**Town & Country Planning Act 1990 (as amended)
Town & Country Planning (Development Management Procedure) (England) Order 2015
Application for Planning Permission for Works or Extension to a Dwelling**

Development Formation of new access together with dropped kerb crossover and formation of gravelled hardstanding

Location Greenock Villa Clyde Road Felpham

Site Plan
Scale 1 : 200

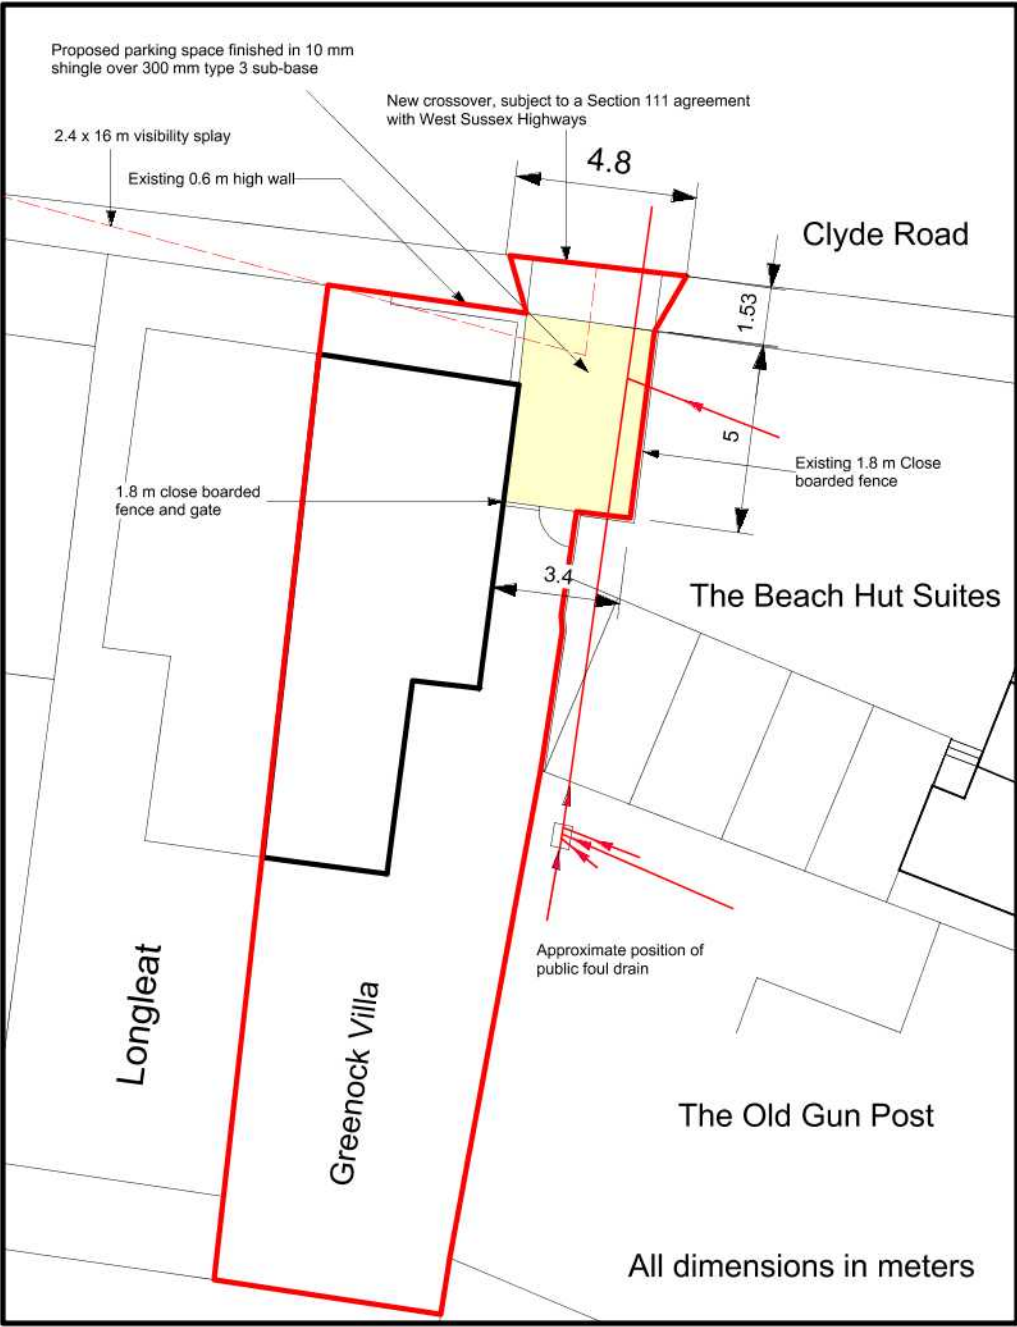
Crossover: Please show the shape of the crossover more clearly and include dimensions to show the proposed size of the crossover.

Site Location Plan
Scale 1 : 1250

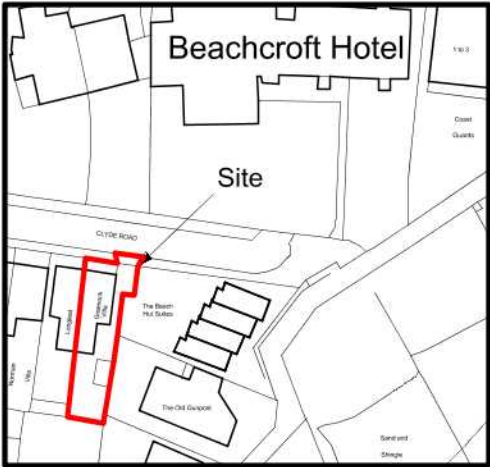
Location Plan: Please include the pavement within the red line of the location plan.
